**Re: 134-140 Marsden Street, Parramatta (V by Crown)
Egress Provisions Separating Serviced and Residential Apartments**

As requested we have reviewed the general BCA Compliance of the overall development and prepared under separate cover detailed BCA Assessment Reports. The purpose of this correspondence though is to provide specific comment on the egress compliance provisions regarding the separation of the proposed serviced and residential apartments at levels 2 to 9 with the relevant egress provisions of D1 and D2 of the BCA.

LEVEL 4-9

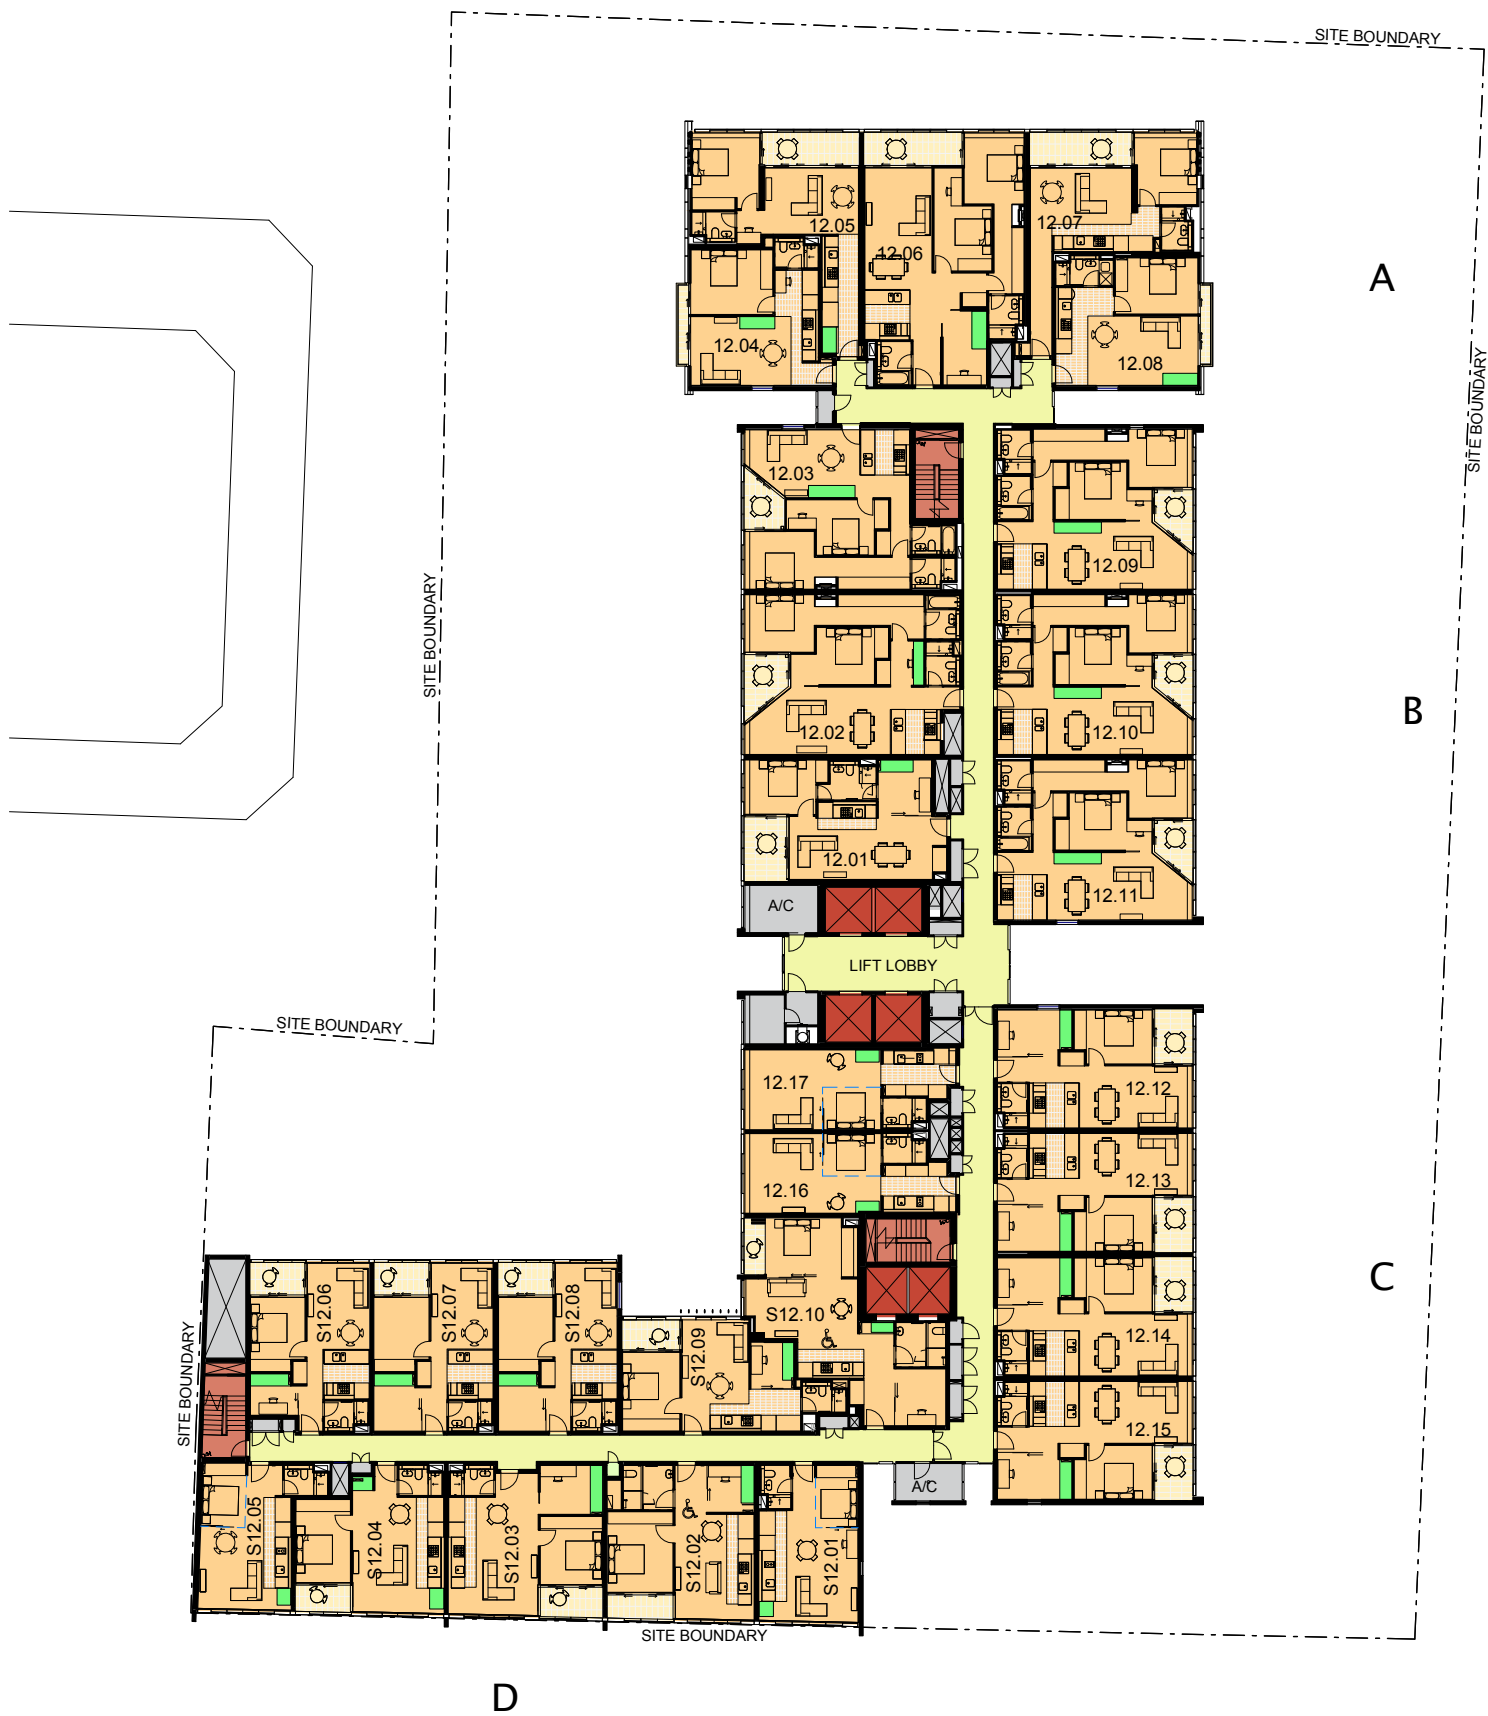
Outlined in the part plan below, is the separating doorway between the Serviced and Residential apartments which is typical on levels 2 to 9:

To maintain secure separation, this egress door will remain securely locked at all times, other than during a fire alarm within the building. The door will be provided with an electric strike mechanism that automatically releases upon either a power failure or fire alarm within the building. This will then enable persons an alternate egress pathway to reach the fire isolated stairways that serve the subject levels.

Egress is required from the Serviced apartments area to reach Stair 02 to enable compliant egress travel distances of D1.4 and D1.5 of BCA to be achieved. As such illuminated egress signage will be provided over the above clouded doorway as well as separate signage to the effect "Emergency Egress Only During Fire Alarm". This way occupants within the serviced apartments portion will not be able to access the residential corridors on a day to day basis and only pass through the doorway in the event of a fire alarm situation.

Such security arrangement to this doorway will still satisfy the provisions of D2.21 of BCA. Subject to this electric strike mechanism being provided. Compliance with the relevant provisions of Parts D1 and D2 will be achieved whilst still maintaining security between the Serviced and Residential apartment portions.
